Application for Removal or Variation of a Condition following Grant of Planning Permission or Listed Building Consent

Reserved matters application for the erection of 1no. dwelling on land between 71 and 75 High Street, Martin

19/0776/RESM

Condition 3

Proj No. 192144-02B Scale 1:200 Date 04/19

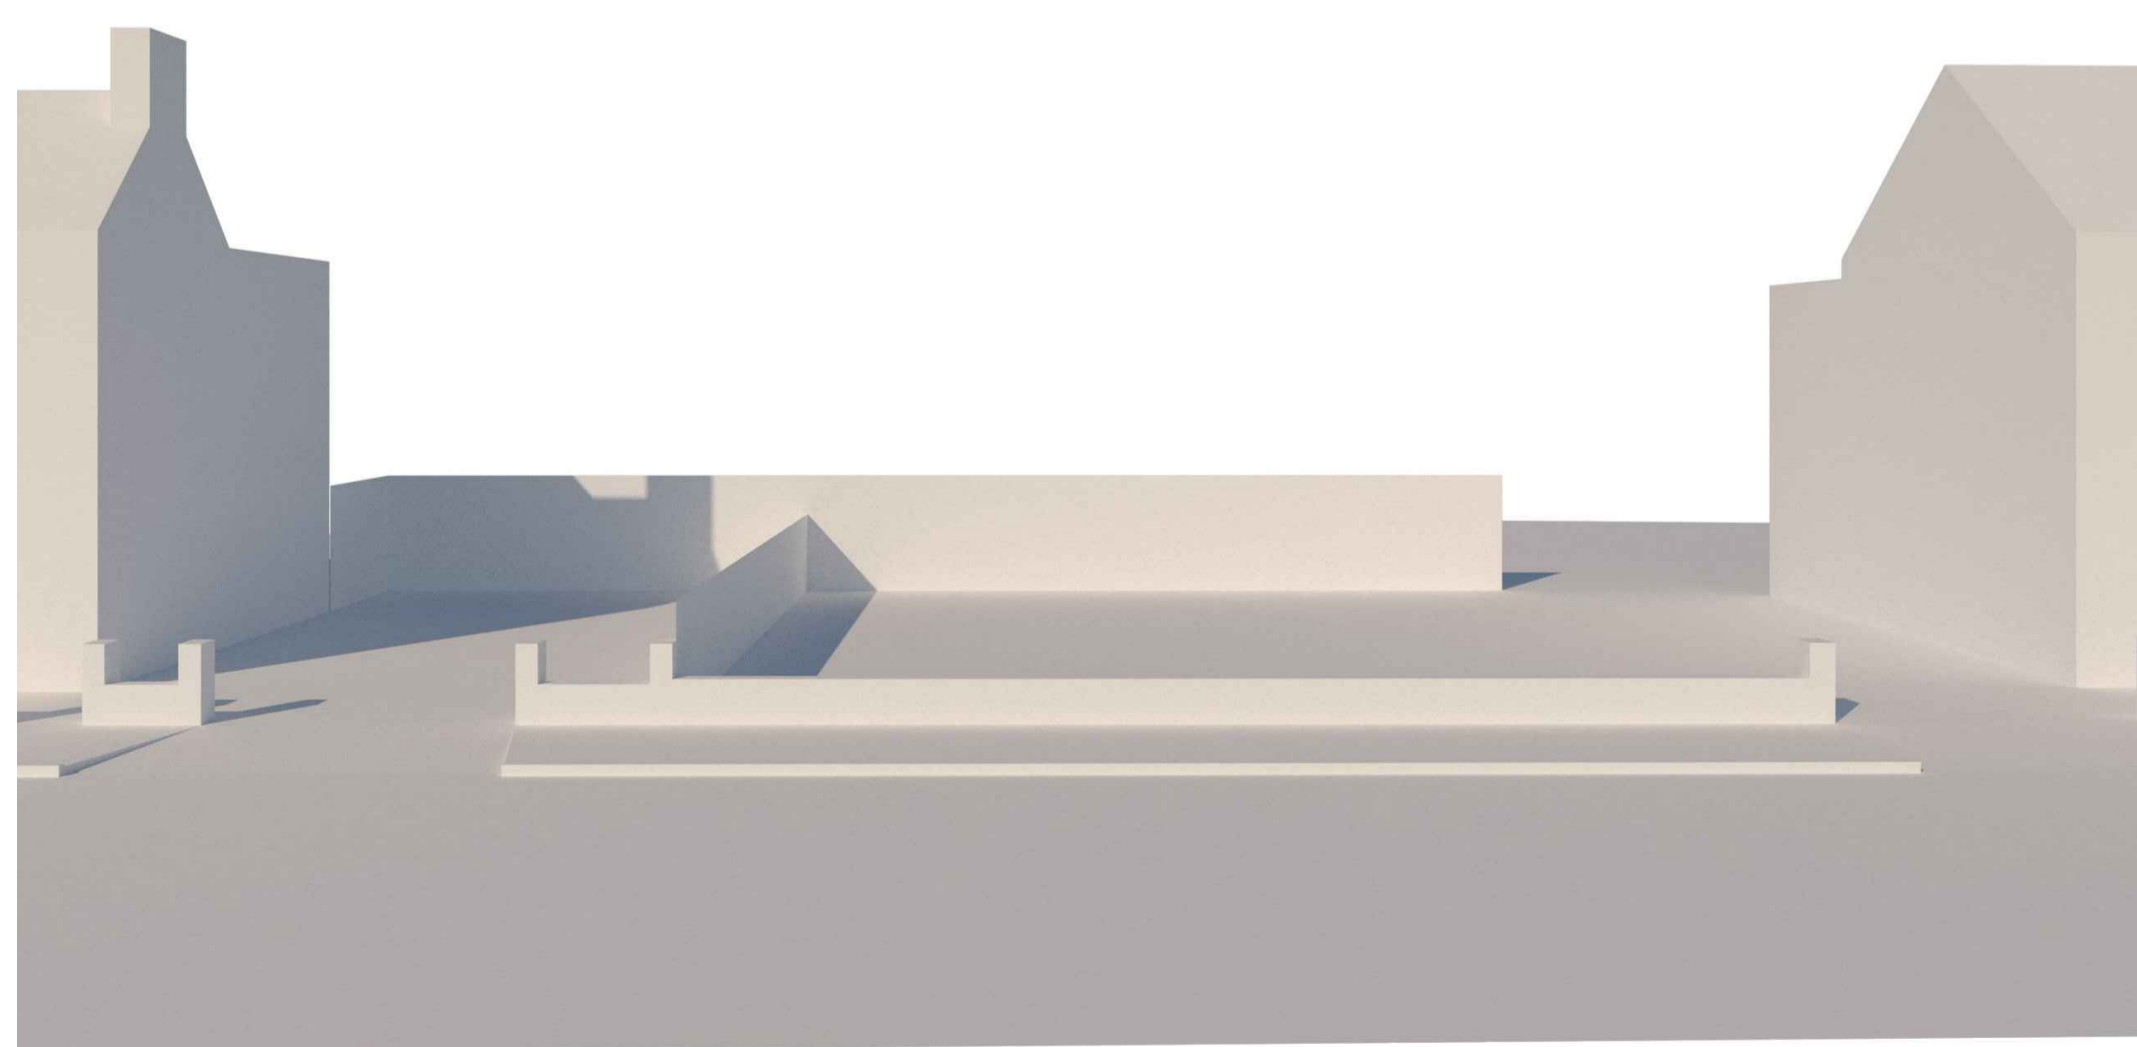
Amended drawings 192144-01c, 192144-02b, 192144-03c show the dwelling with the garage door added to the car port.

Dwg No. 192144-01C  
 Scale 1:100  
 Date 04/19

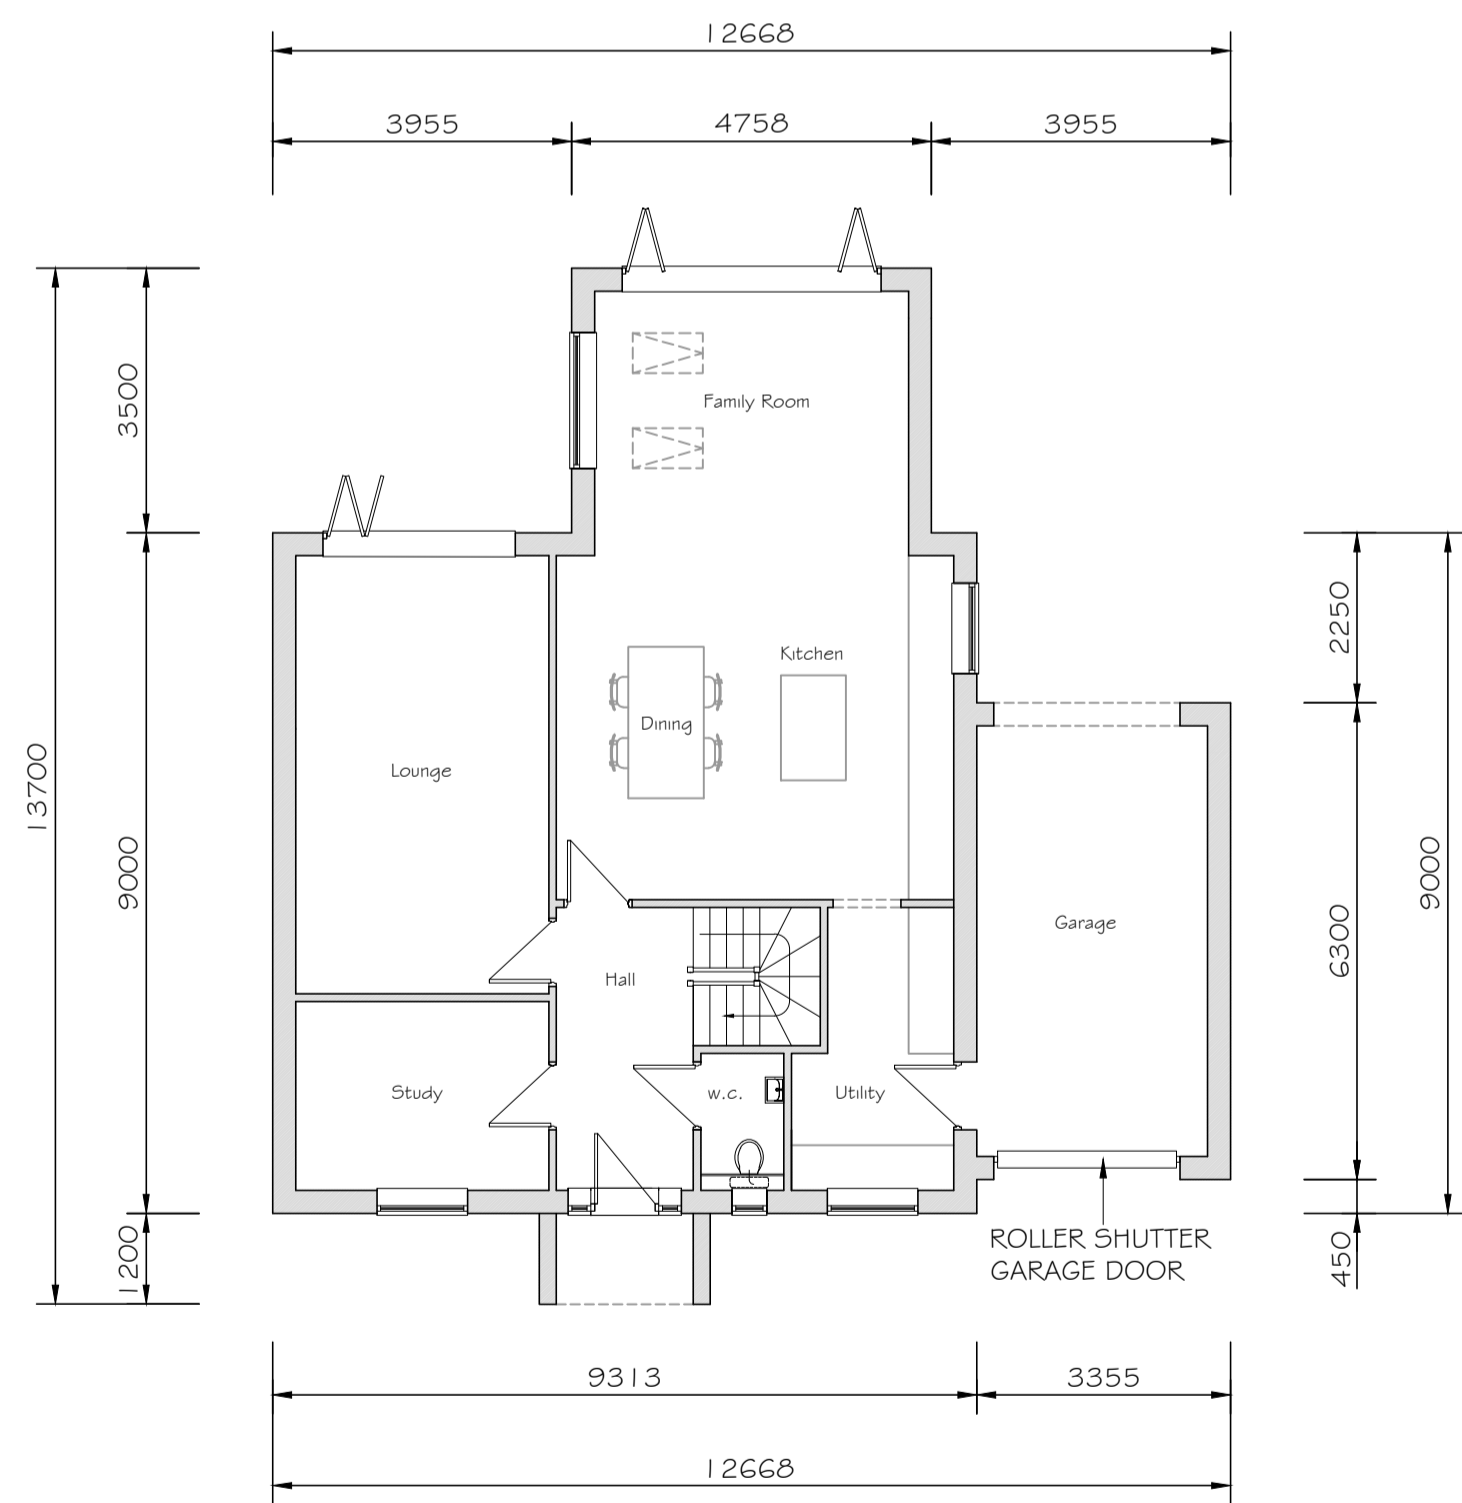
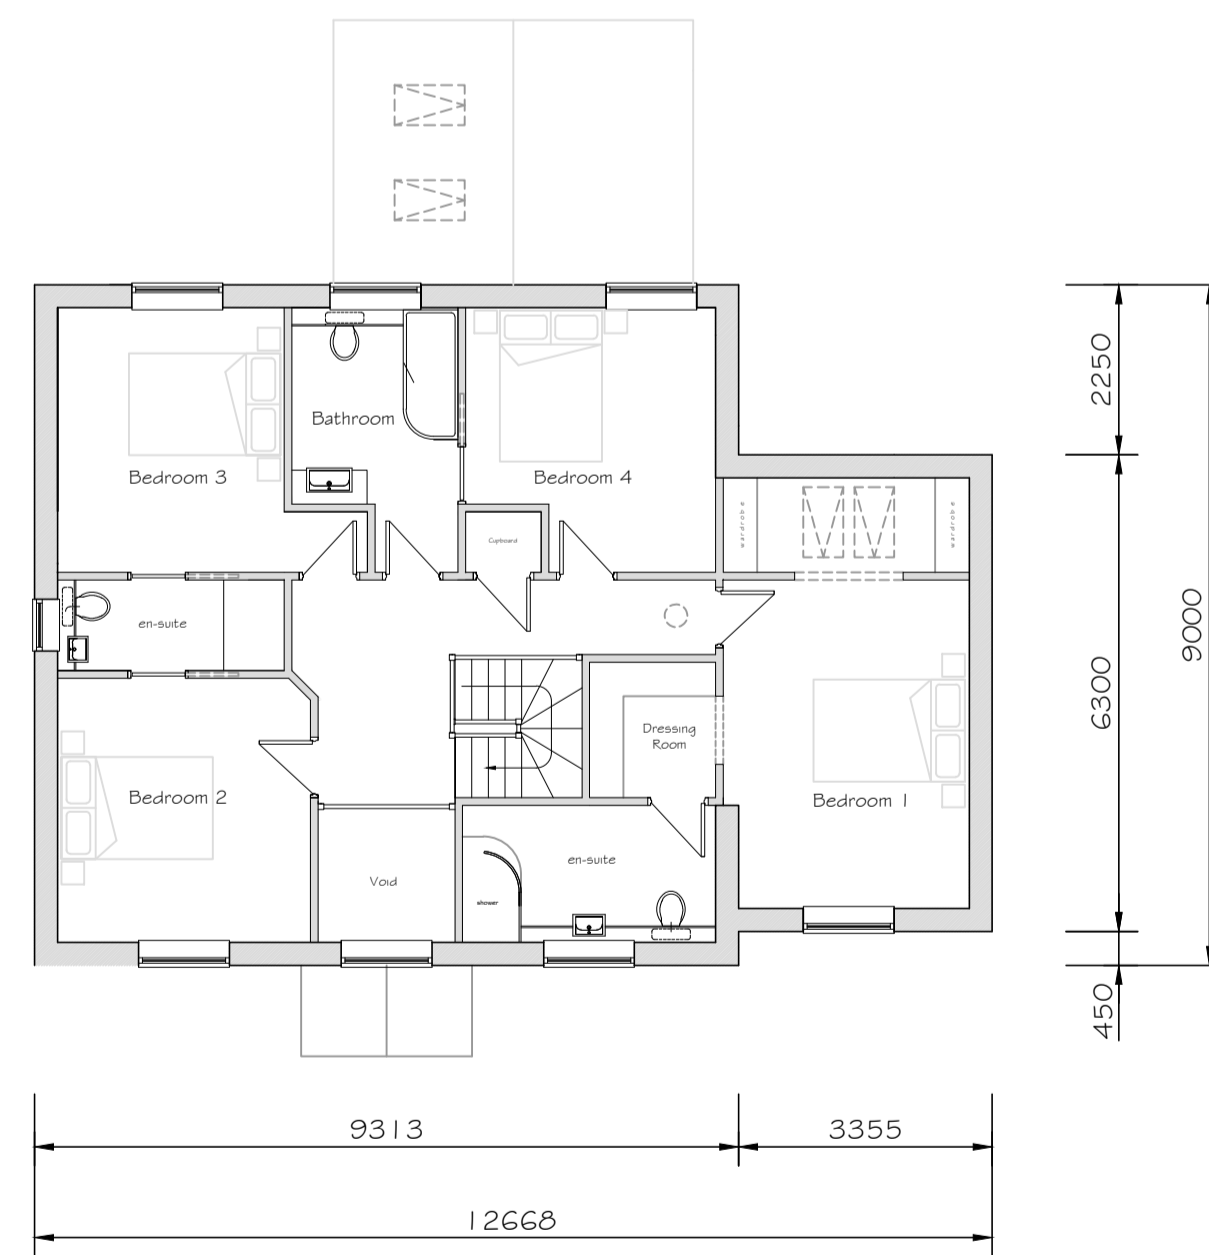
Condition 3- States that there will be no alterations to the car port, including the addition of a garage door.

The dwelling has been completed and a garage door has been used on the car port.

The dwelling has been completed with the addition of the garage door on the front of the car port.
